Coran Chassey, What
1/5 DOG1
Fluoridation inlet not provided

AVENIDA CEDAR CHAVEZ INLET REPORT 9/6/13 BY PB

**CITY OF ALBUQUERQUE
CITY WIDE-ON CALL ENGINEERING SERVICES
(TRANSPORTATION & STORM DRAINAGE)
5015.03**

**TASK 1
AVENIDA CESAR CHAVEZ
DRAINAGE INLET ASSESSMENT
FINAL**

Exhibit 1: Drainage Basin Map

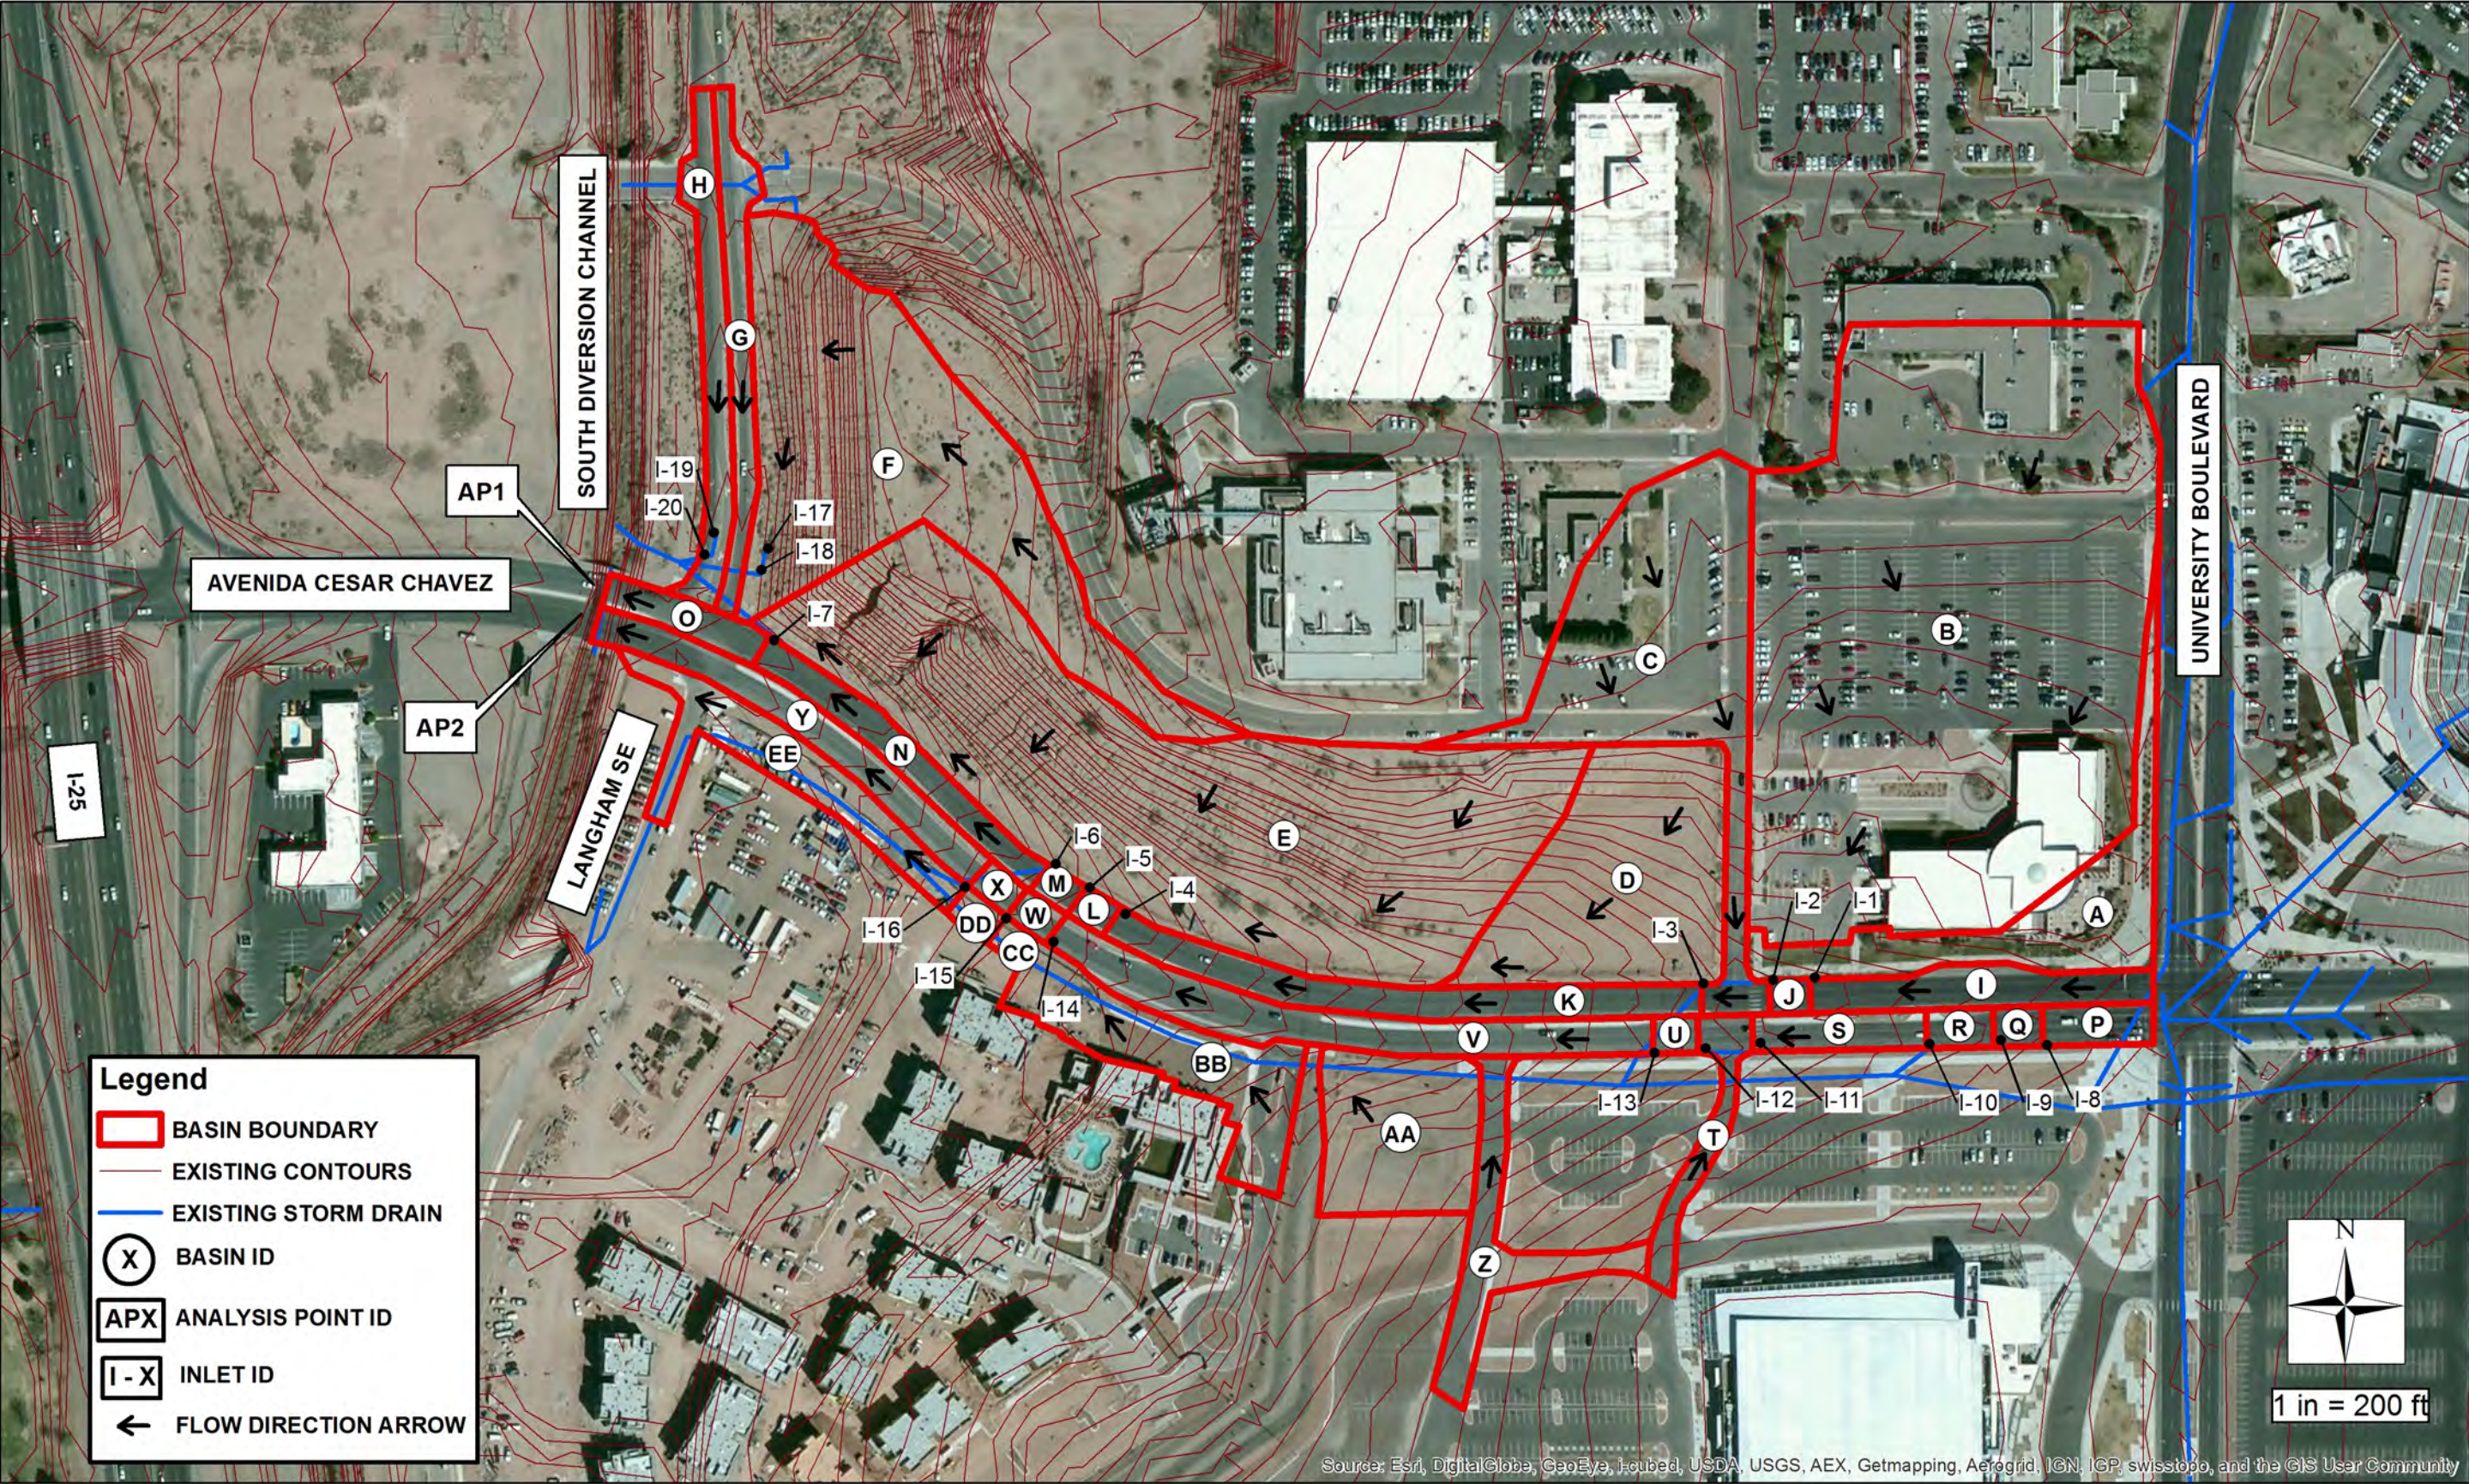
FOR THIS - EXHIBIT 1 PVD
BUT I HAVE SOME BASIN MAPS & NO
EXPLANATION OF ANALYSIS PD
